**Re: Whataburger, 111 Coors Boulevard NW
Grading Plan and Drainage Plan
Engineer's Stamp Date 12-2-14 (K10D001B)**

Amy L. D. Niese, P.E.
Senior Engineer, Hydrology
Planning Department

STORMCHAMBER® TYPICAL CROSS-SECTION INSTALLATION (PROVIDED AS AN ILLUSTRATED EXAMPLE ONLY)

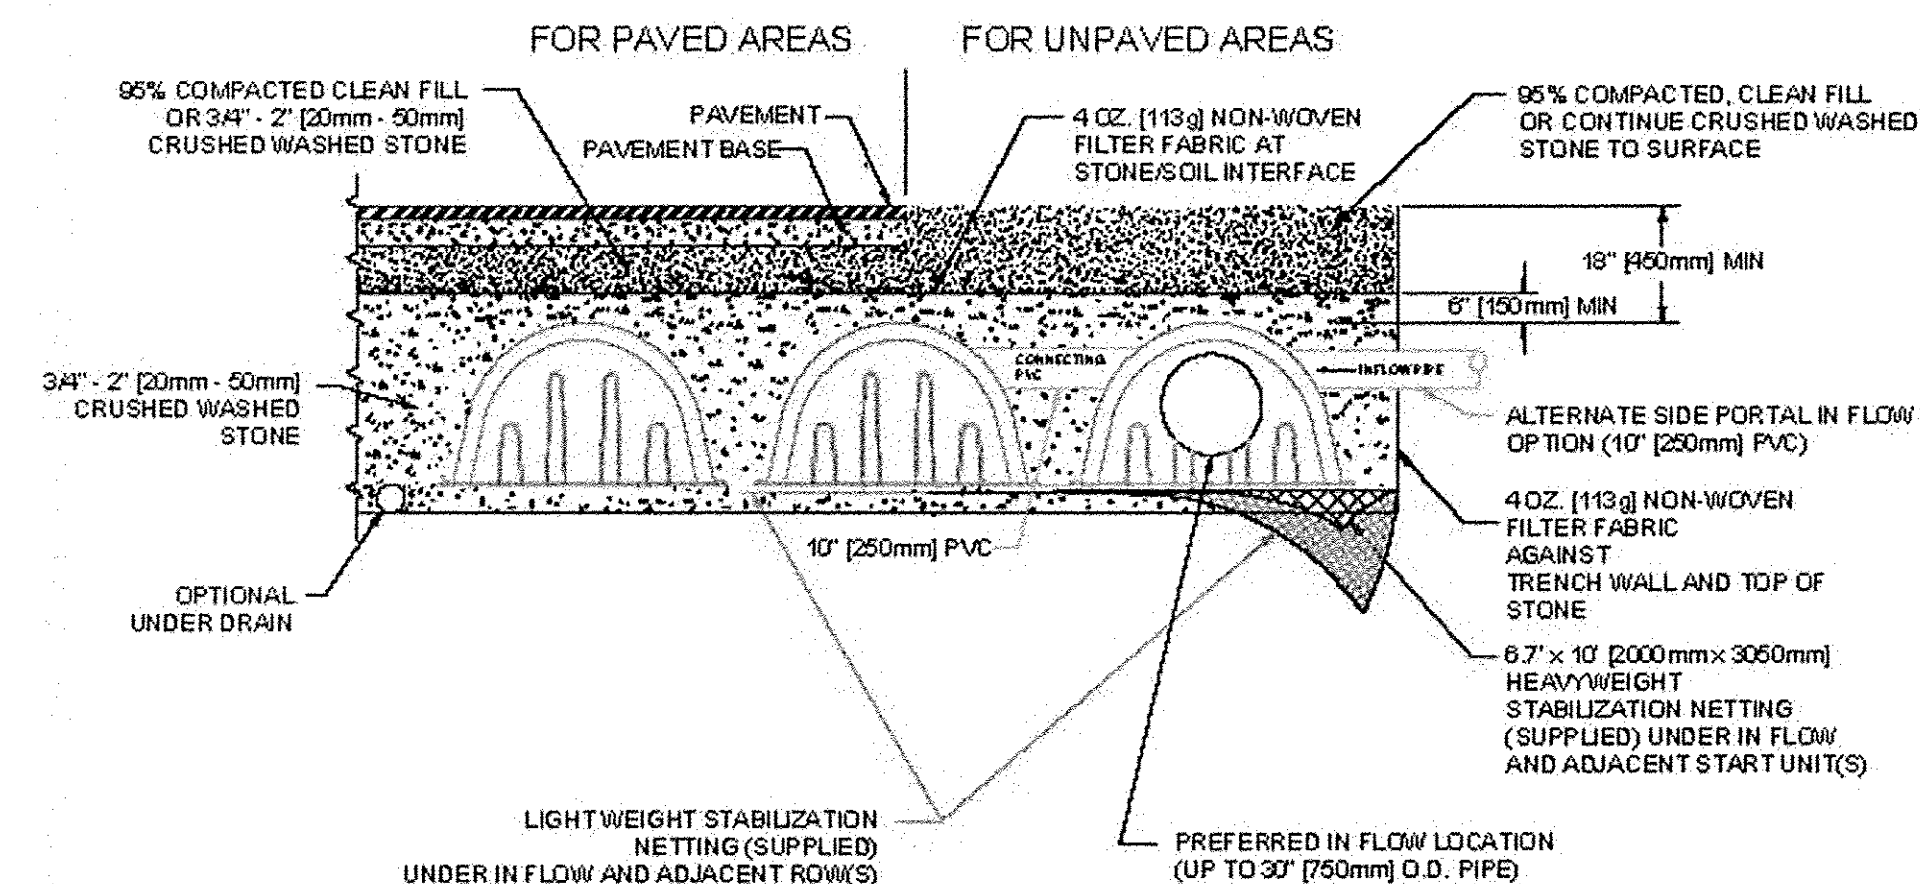
4. How was the Stormchamber sizing determined? How many risers will be with this system? Is the only riser the inlet in the middle of the system? If more than one, where will they be located exactly? On the Stormchamber detail sheet, optional items are called out on the lower left cross-section detail. Will those options be utilized with this system?
